TO:	Arun District Council FAO: Claire Potts
FROM:	Highways, WSCC
DATE:	26/09/2018
LOCATION:	Land south of New Road (A259) and East of Brook Lane, Angmering
SUBJECT:	A/23/15/OUT Hybrid application Full Planning Permission for a retail unit (Class A1) comprising 1,487sqm (1022sqm ground floor and 465sqm mezzanine) with associated access, car parking, servicing, landscaping & associated works. Outline Planning Permission for a public house (Class A4) comprising 581sqm at ground floor level - This is a Departure from the Development Plan Amended plan Highway Access Plan REDW-3167-138.
RECOMMENDATION:	☐ Advice ☐ Objection ☐ Modification ☒ No Objection ☐ More Information ☐ Refusal

The applicant has submitted a revised highway access plan drawing number REDW-3167-138 which proposes some amendments to the previously submitted site access.

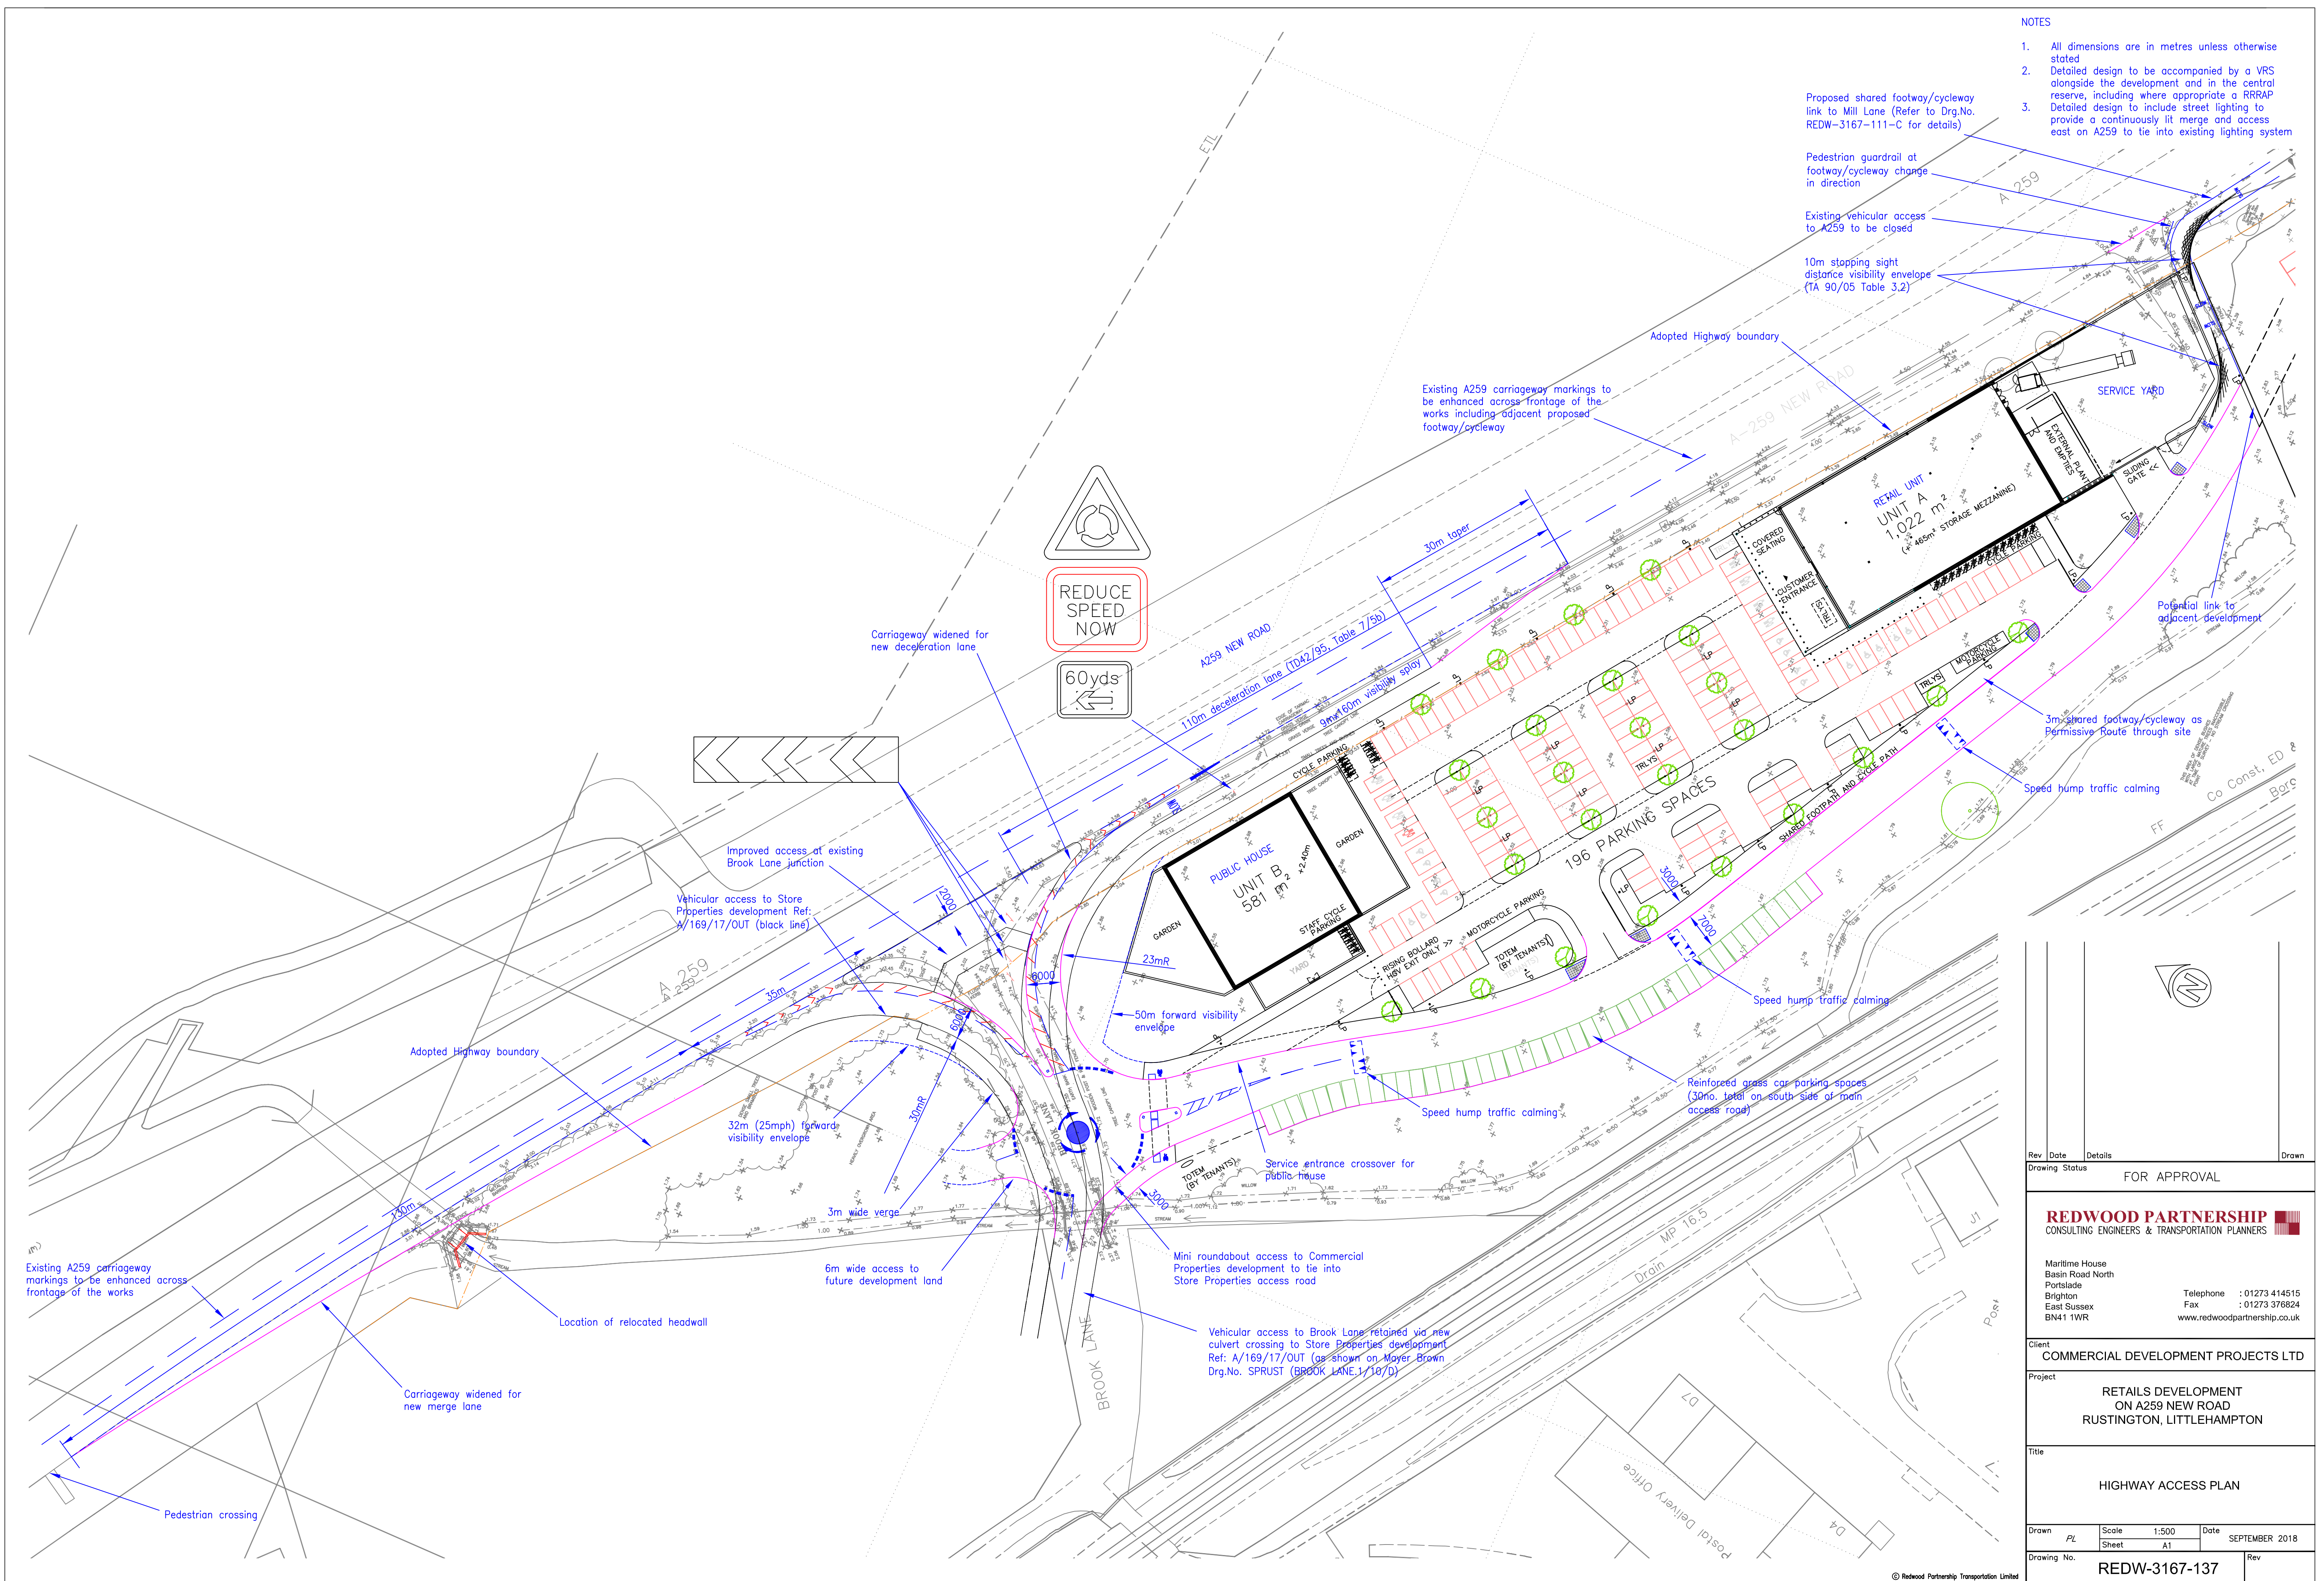
A departure from standard for a 20m radii has already been accepted by West Sussex County Council (WSCC) as Highway Authority and given the applicant is now providing a larger entry radii of 23m this is deemed acceptable.

The applicant has also demonstrated that a visibility splay of 9m x 295m can be achieved to the east of the proposed access; which accords with the relevant standards. The applicant has also demonstrated that the proposed access arrangements facilitate access to the adjacent site permitted under A/169/17/OUT.

The Highway Authority therefore has no objections to the proposed access arrangements as detailed in drawing number REDW-3167-138.
